## Application for a Non-Material Amendment Following a Grant of Planning Permission

Single storey side and rear wrap around extension, including garage conversion and associated replacement window

PL/2023/01112/MINFHO

The proposed non material amendment is to construct a straight mono-pitch roof over the newly extended area without the small hip originally proposed.

CLIENT BB		DATE APR 24
DRAWN BY AC	SCALE (@ A1) AS SHOWN	PROJECT NUMBER -
DRAWING NUMBER A201	REV D

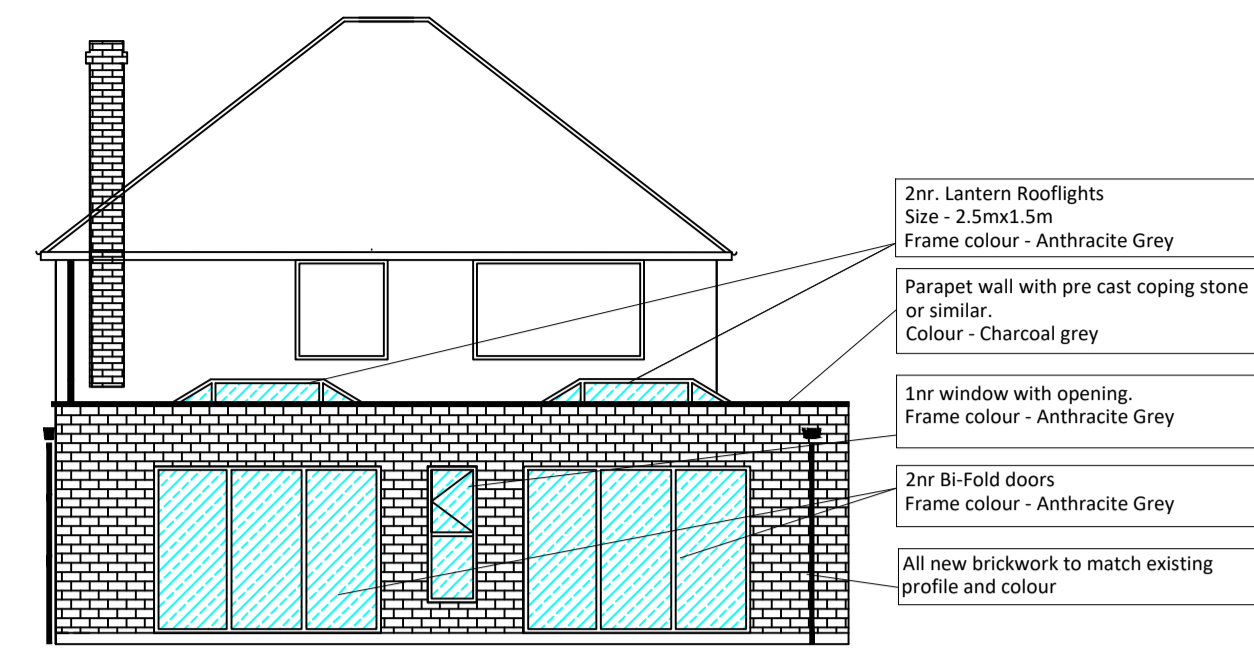
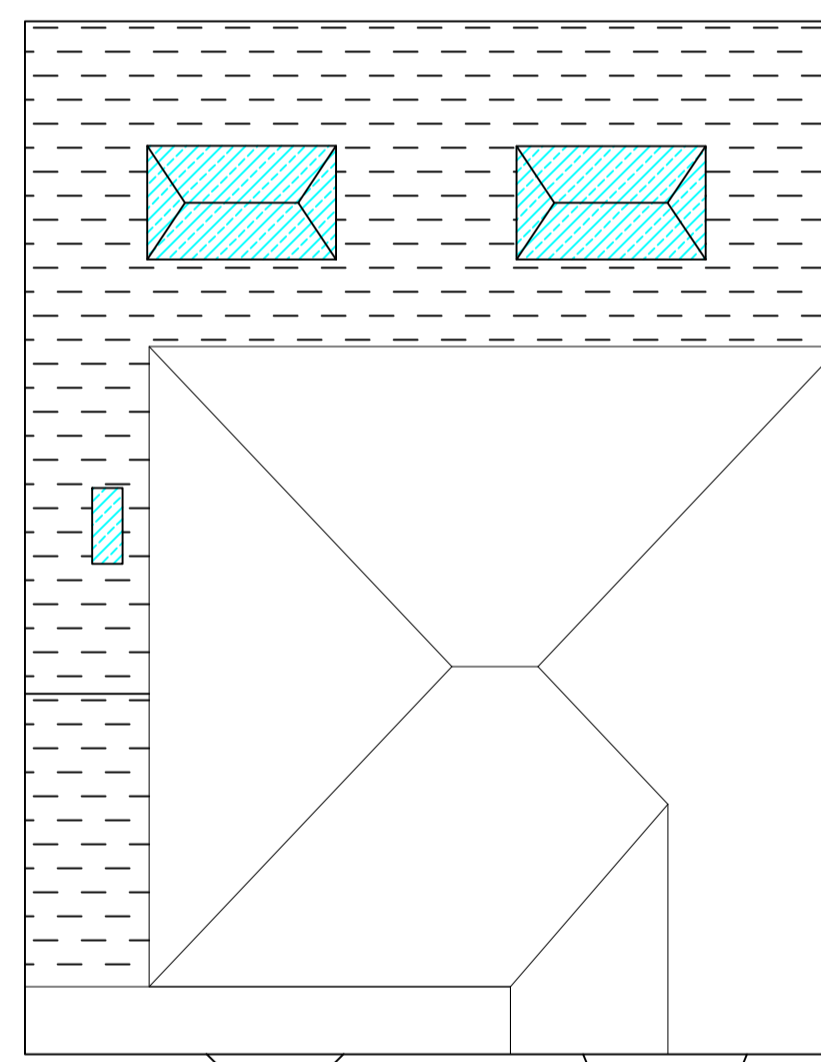
This would not only visually improve the front elevation but also tie in the wall to the mono pitched roof as part of wrap around extension neatly.

111 Bills Lane B90\_RevD-Proposed A201
